CHECKLIST RESPONSES: HEADRICK RESIDENCE PHASE 2
Intake Screening - 2202-128 – Incomplete – 8822 SE 62ND ST, MERCER ISLAND

INTAKE COMMENTS PLANNING		Reviewer	Lauren Anderson	
		Email	Lauren.Anderson@mercerisland.gov	
		Status	Not Accepted – Resubmit Entire Submittal Package for Reviewer App	
Land Use actions Required				
<input type="checkbox"/>	Shoreline Permit			
<input type="checkbox"/>	Critical Area Review 1			
<input type="checkbox"/>	Critical Area Review 2			
1	<input checked="" type="checkbox"/>	Environmental Review (SEPA Checklist)		
	<input type="checkbox"/>	Accessory Dwelling Unit (ADU)		
	<input type="checkbox"/>	Lot Line Revision		
	<input type="checkbox"/>	Other		
Surveys Required Prior to Final Inspection				
	<input type="checkbox"/>	A building height survey is required prior to final inspection		
2	<input checked="" type="checkbox"/>	An impervious surface, lot coverage, and or hardscape survey is required prior to final inspection		
3	<input checked="" type="checkbox"/>	A property line/setback survey is required prior to final inspection

SHEET: A2.1

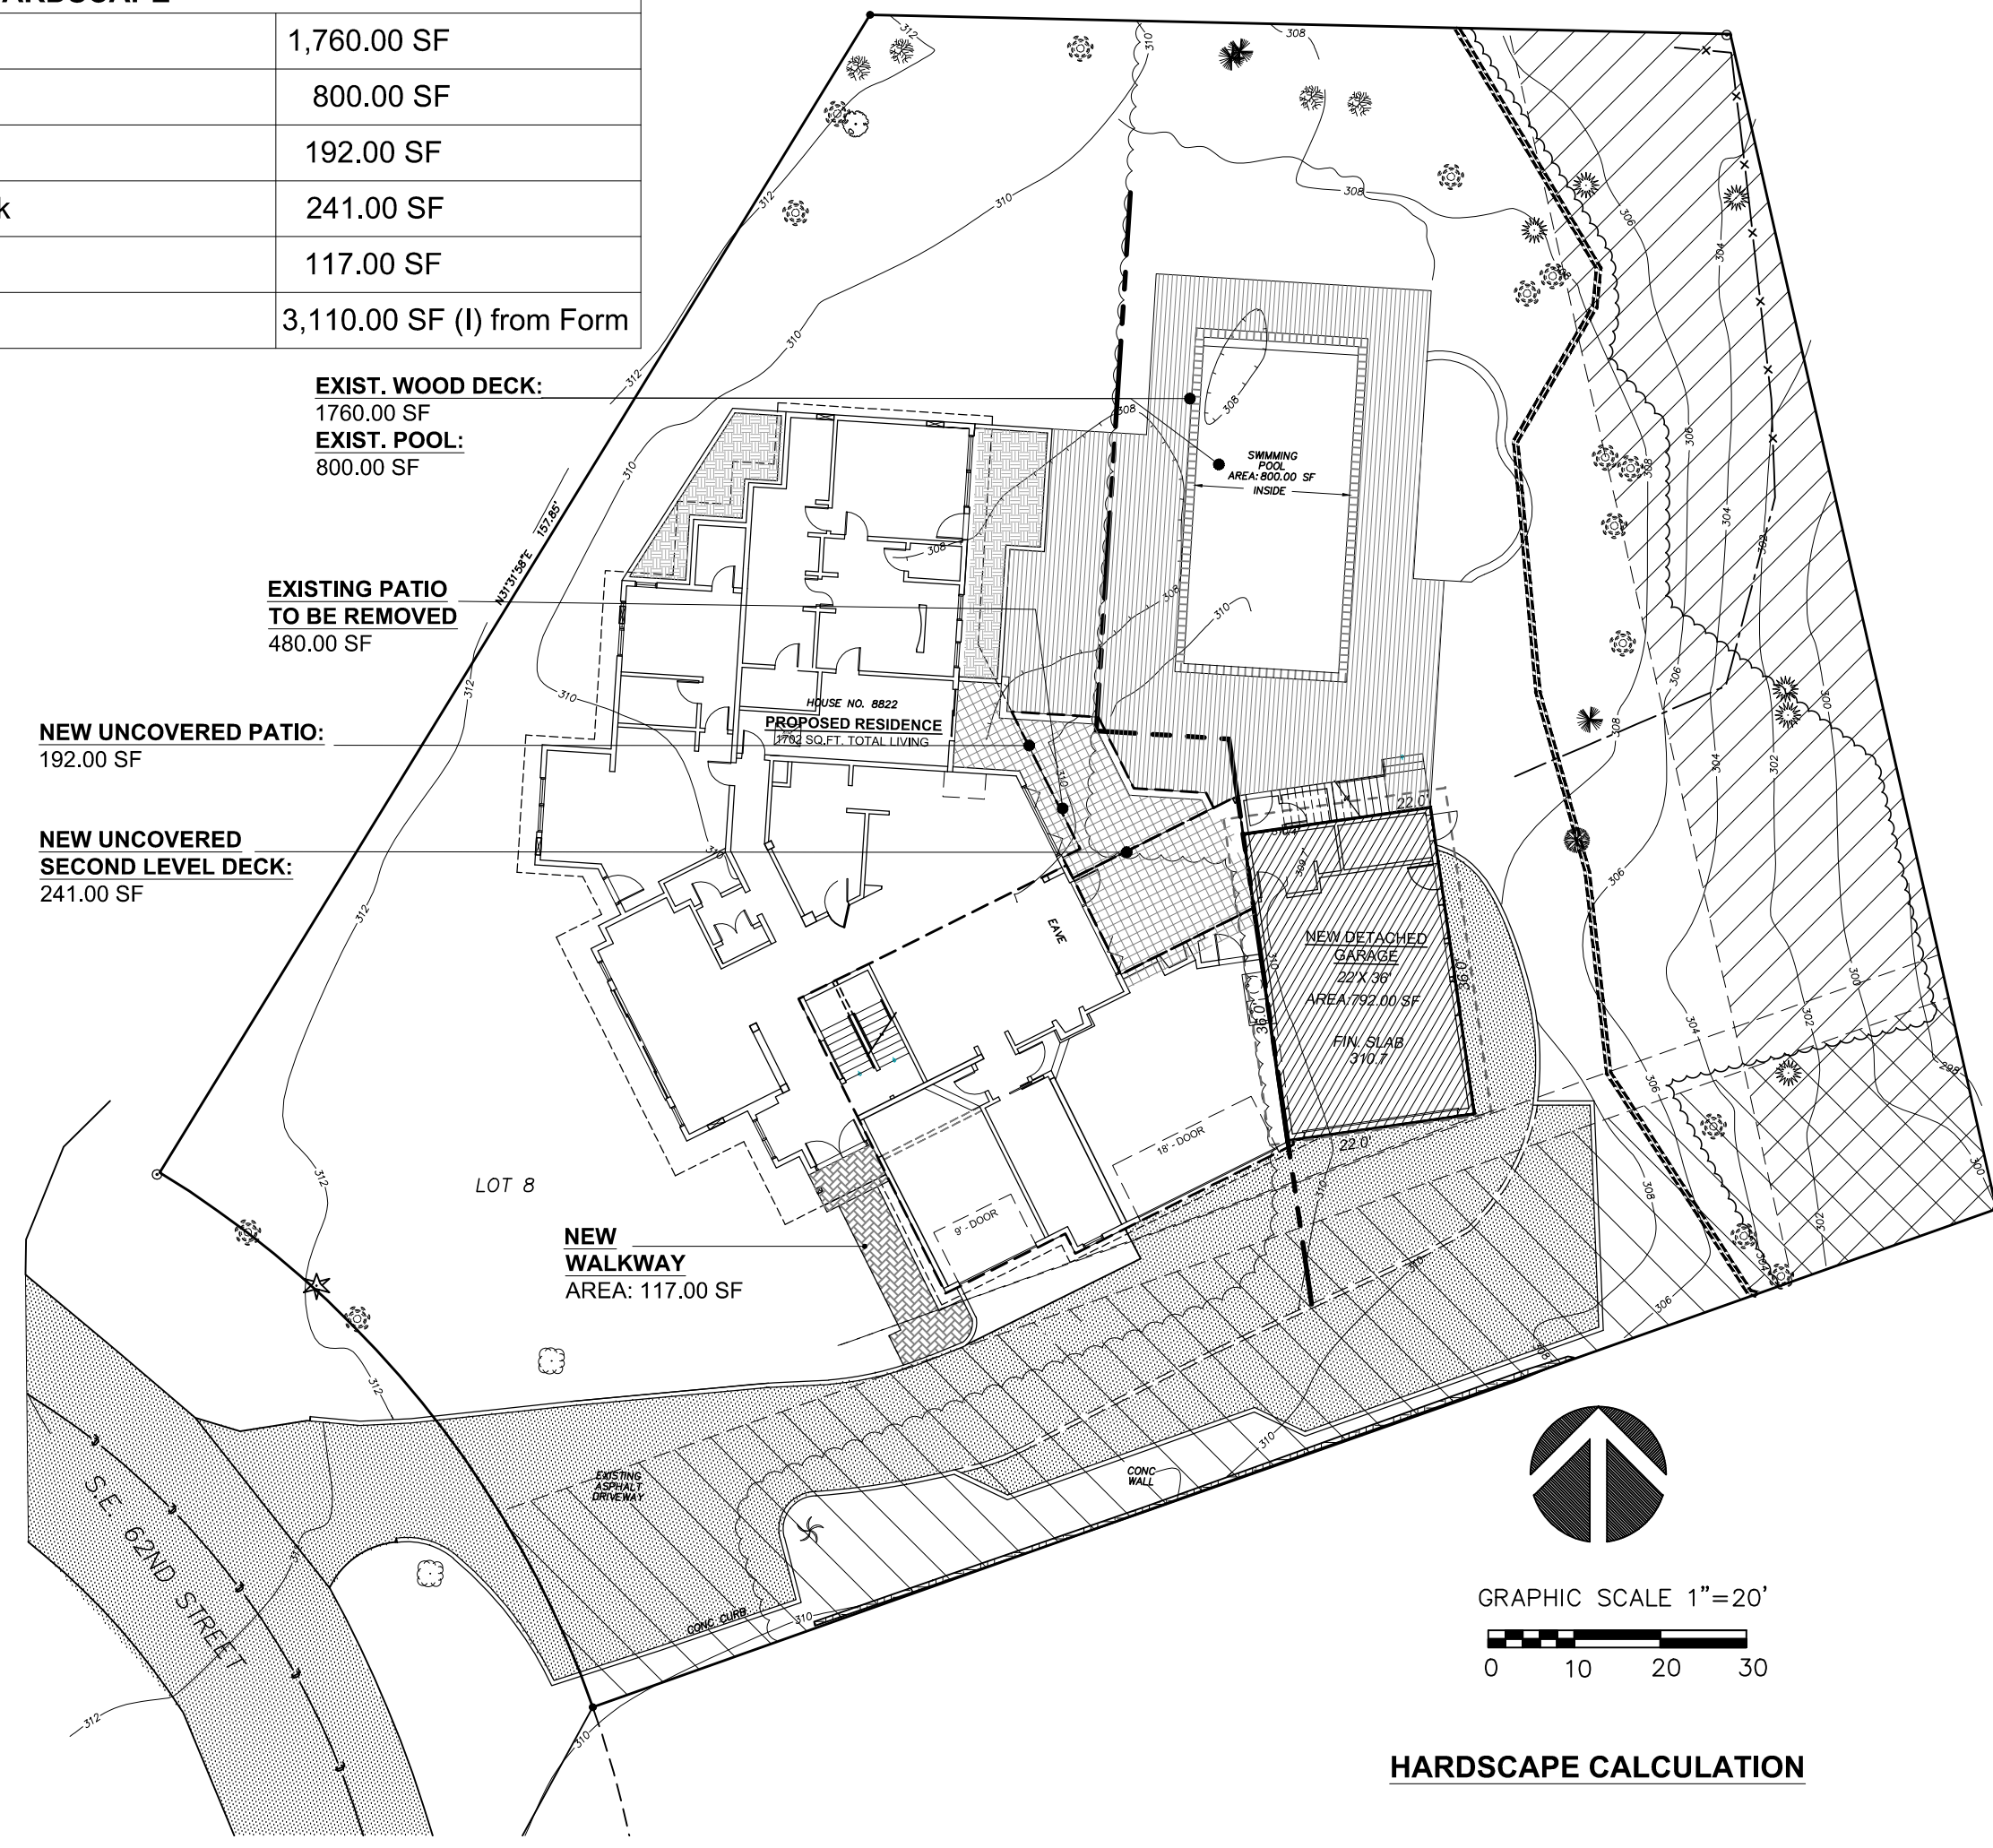
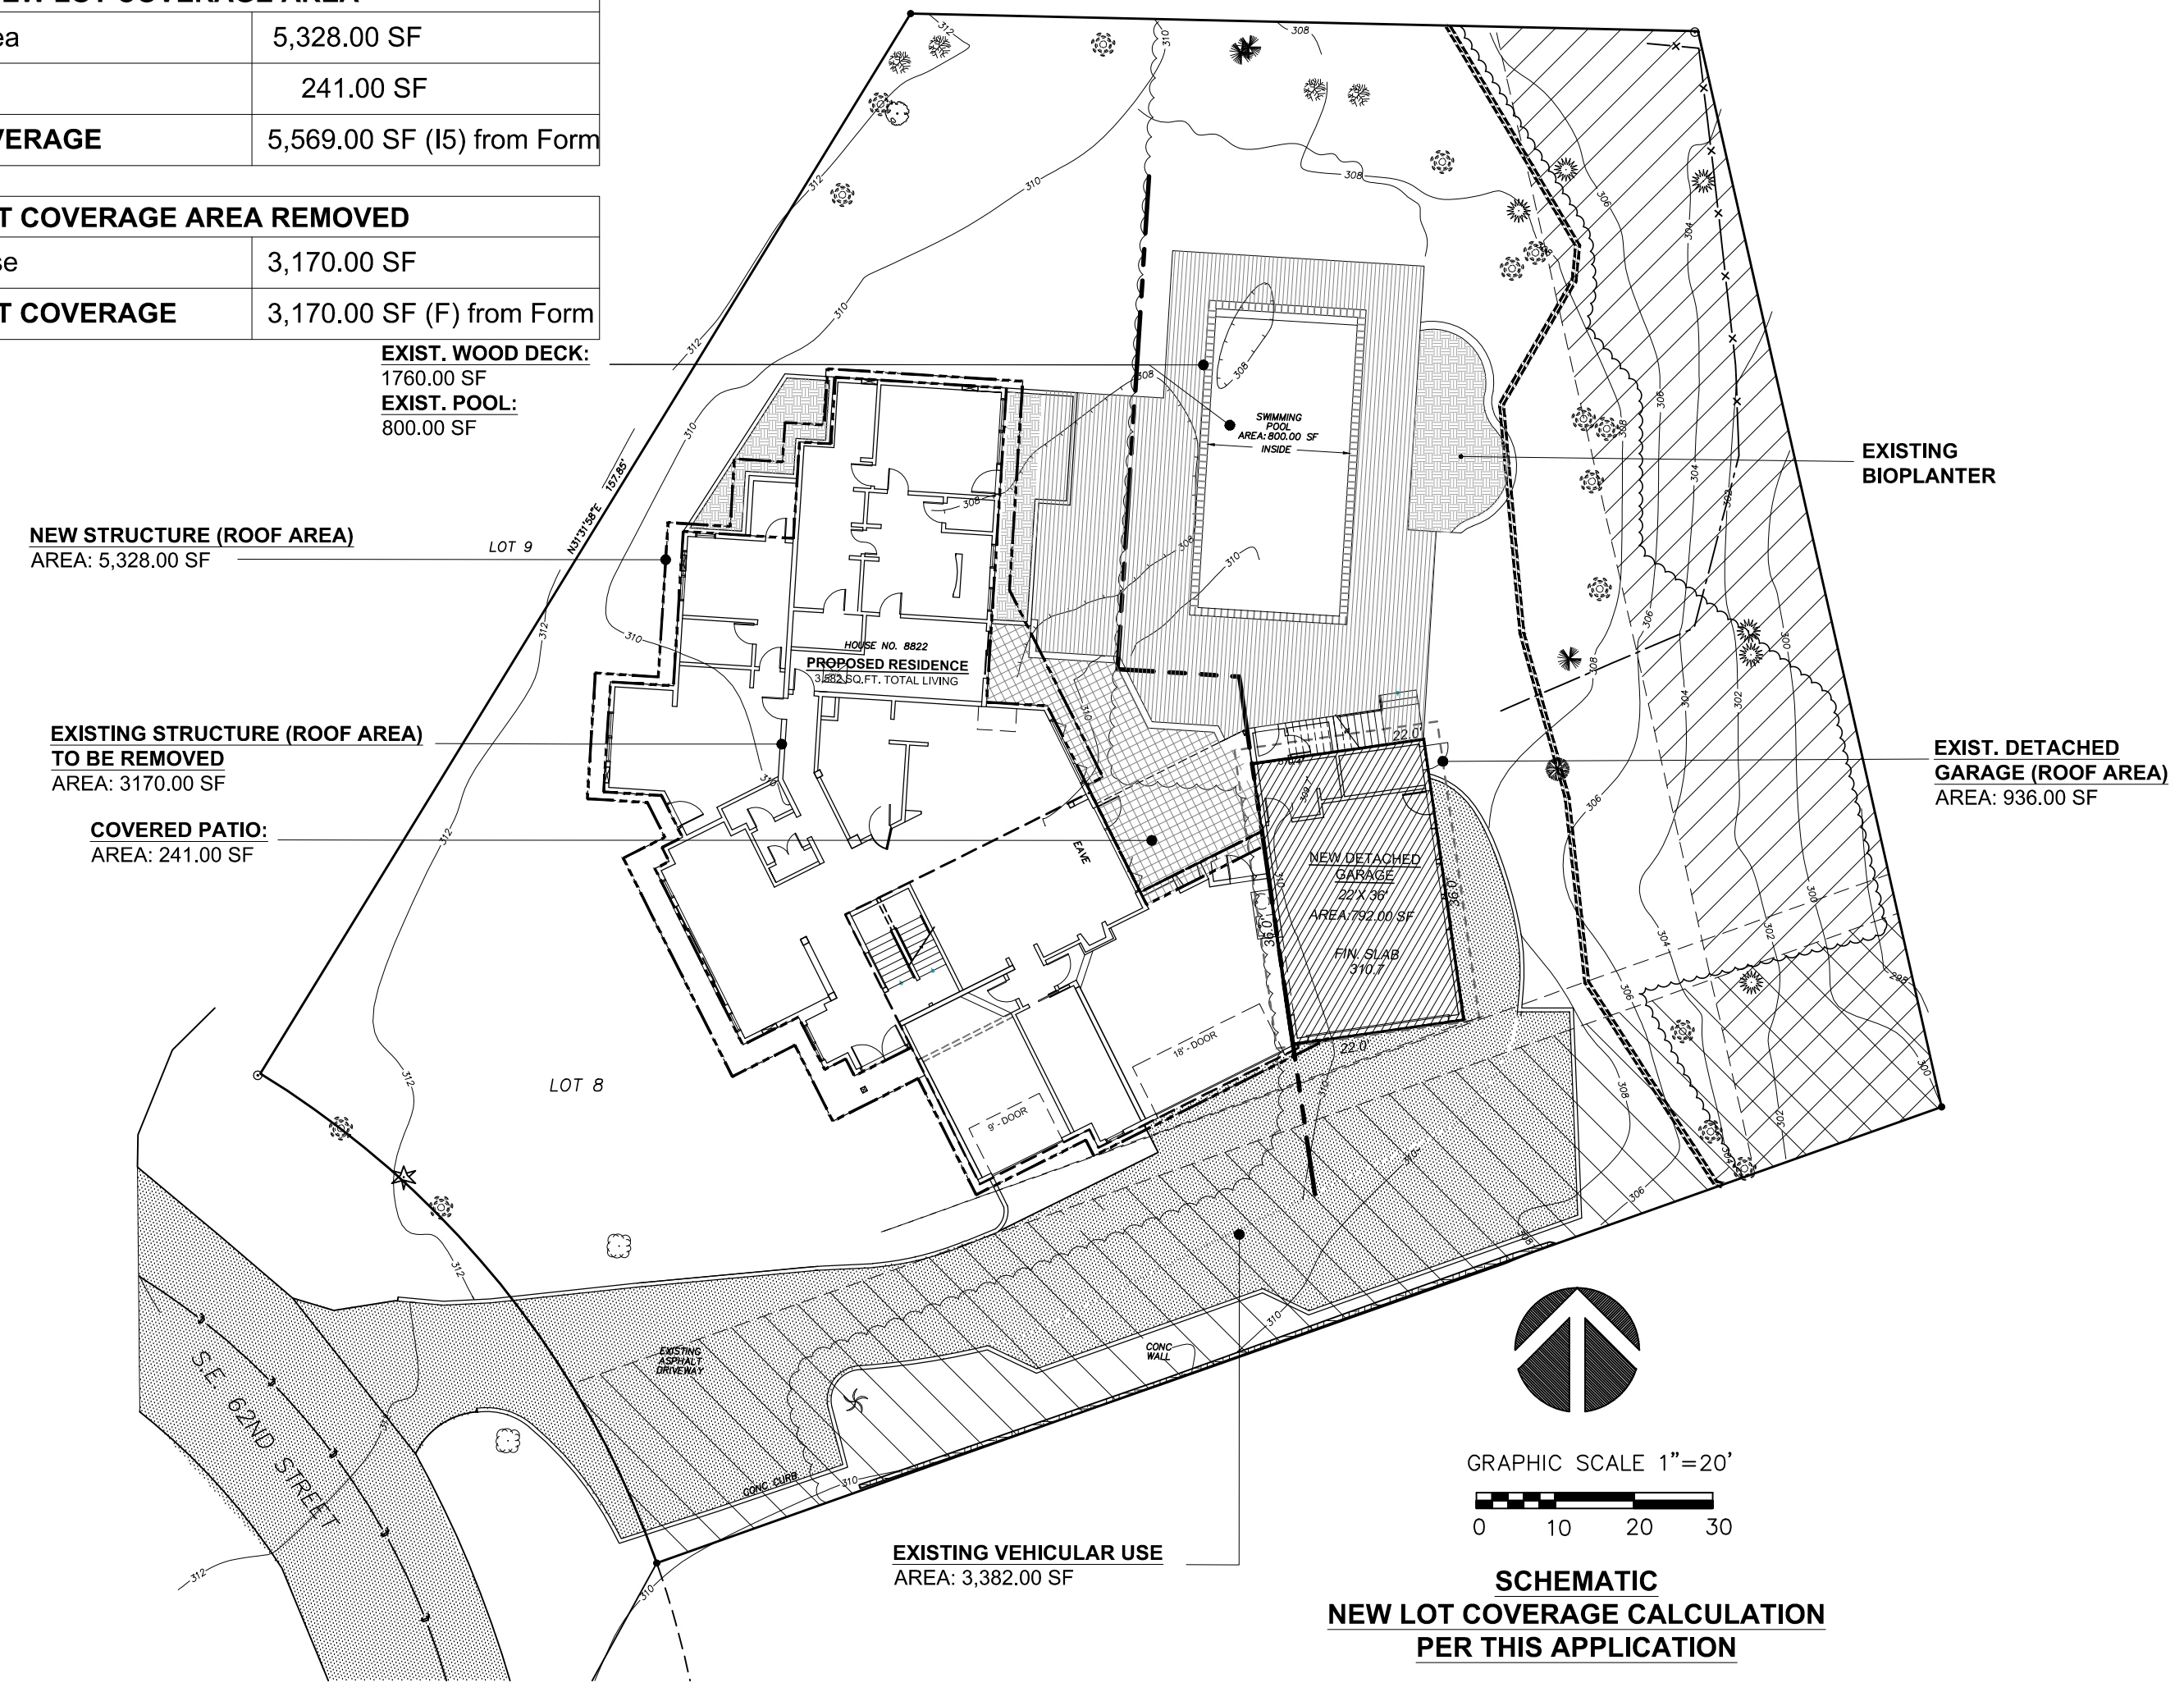
(2) A note has been added to the sheet A1 & A2.1 requiring as-built survey for impervious surface, lot coverage, and or hardscape area prior to final inspection

(3) A note has been added to the sheet A1 & A2.1 requiring as-built survey for property line/setback survey prior to final inspection.

(4) A site plan has been added showing dimensioned foundation & location, setbacks, and property lines. See sheet A2.1

(11) Indicate utility easements. Shown on site plan A2. Text of easements on sheet A2.1

18 Plan set: Label the 25' storm easement and the note recording number (198809140722). Label the sewer & storm easement and note the recording number (198202230542).

(18) Storm drainage easement and storm maintenance easement shown on site plan A2. Easement documents shown on sheet A2.1.
